From: Steven Shaw [REDACTED]
Sent: 29 November 2019 15:13
To: Michael Eastham [REDACTED]; Clark, Robert [REDACTED]
Cc: Bernadette Gledhill [REDACTED]; Jamie Brown [REDACTED]
Subject: RE: Littlehampton: CEMP Rev B - LU/339/19/DOC and LU/340/19/DOC

We have reviewed the latest CMP and there are still aspects that need amending. WSCC have the following comments to make:

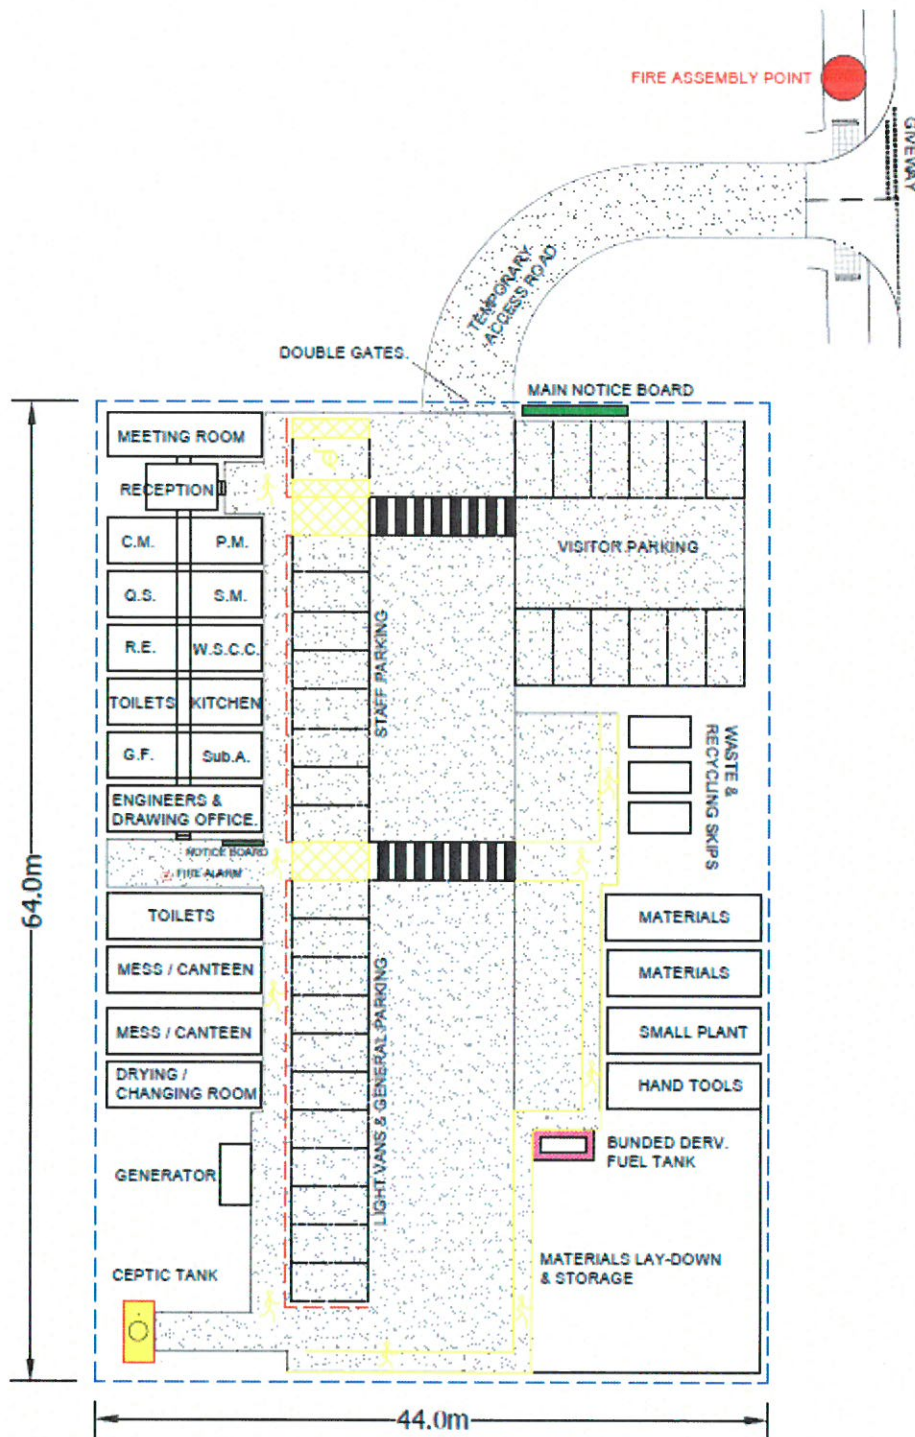
- Parking areas have not been demonstrated i.e not shown or laid out therefore difficult to know how much contractor parking could be housed. Clarification on the level of parking and its design and layout should be provided.
